# Charlotte Department of Transportation

## Memorandum

**Date:** March 6, 2008

**Subject:** Rezoning Petition 08-059: Located on the east side of the I-85 and City Boulevard Interchange

Open Space: +/- 30 Ac. (18%)  
 \*\*excludes previously approved open space (5 ac.)

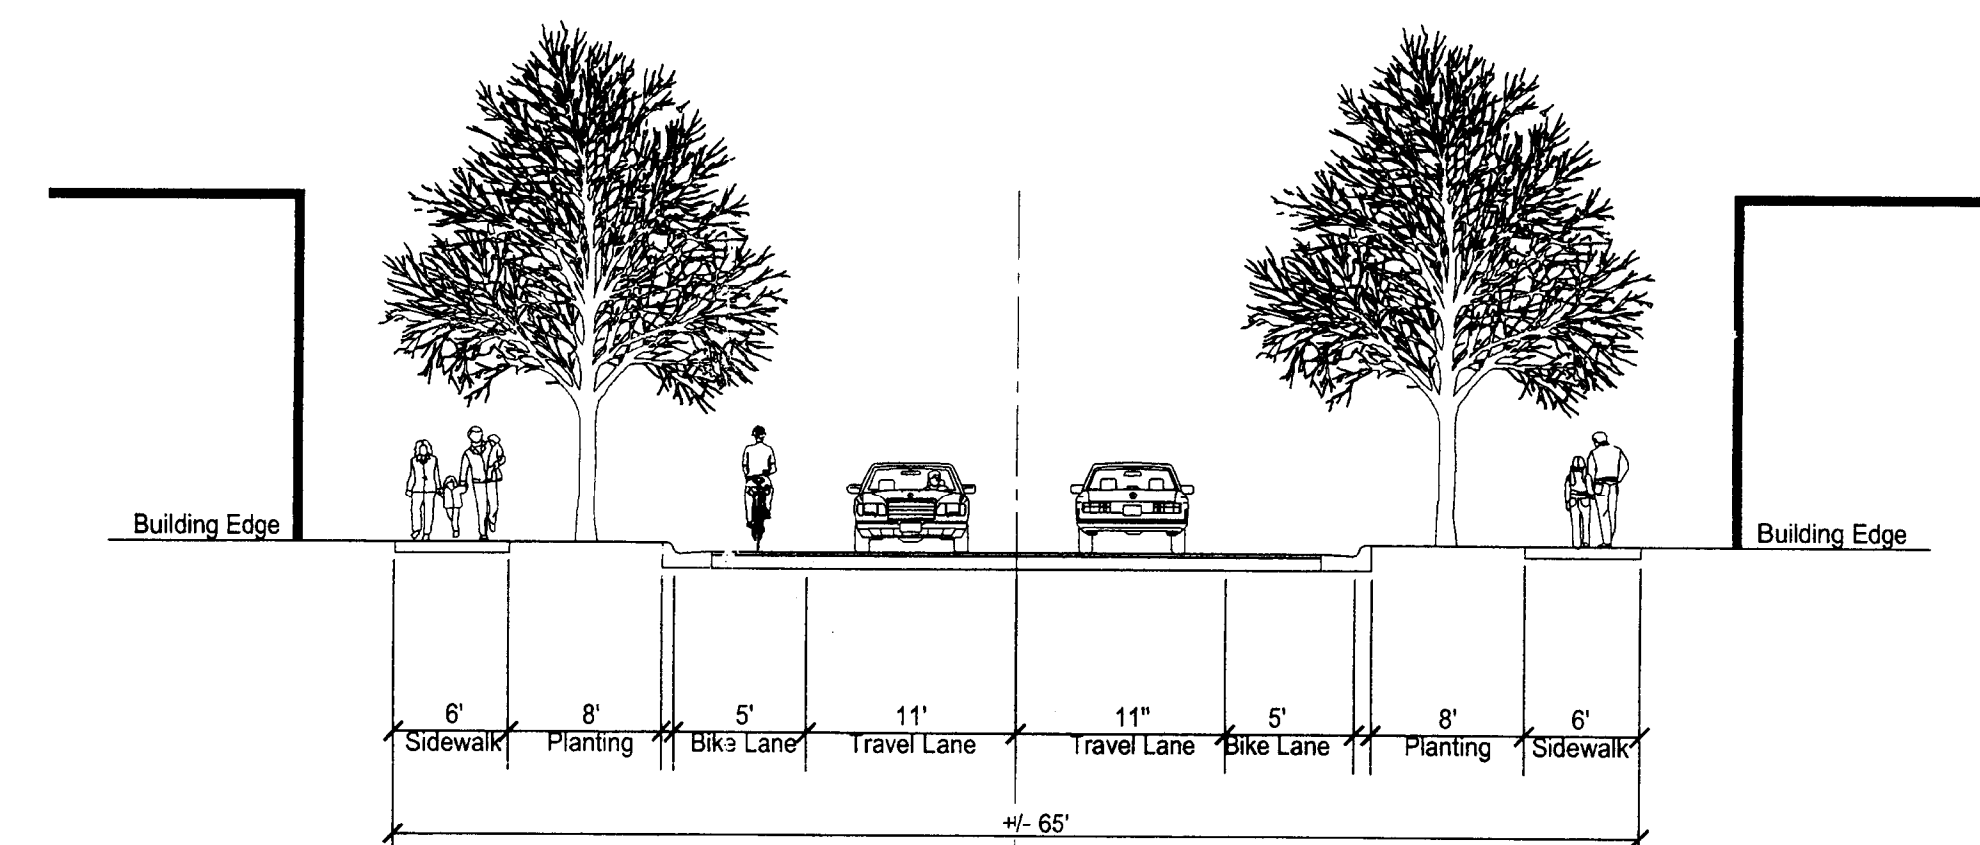
7. The middle portion of IKEA Boulevard (from IKEA to Shopping Center Drive) is classified as an Avenue (Urban Street Design Guidelines, USDG). Cross-sections C-C and D-D need to reflect this. Due to the intensity of proposed development and the mix of land uses, 8-foot sidewalks need to be provided along IKEA Boulevard. All other local streets/cross sections will need to conform to the appropriate USDG street type.

10. All street dimensions, such as lane widths or parking bay widths, on sections A-A, B-B, C-C, and D-D need to be referenced to the face of curb instead of the back of curb.

1. Because it is a Main Street, Section C-C of Ikea Boulevard should use hardscape, with trees in tree pits, instead of a dedicated planting strip.
2. This project is located within ¼ mile of transit service. However, such a dramatic increase in employment, households and services would likely require a reconfiguration of transit to adequately serve such a significant increase in demand. This project is also located within ¼ mile of two planned transit stations on North Tryon Street (City Boulevard and Rocky River stations). The additional street connections described above will better facilitate multimodal access between the future stations and the various proposed uses.
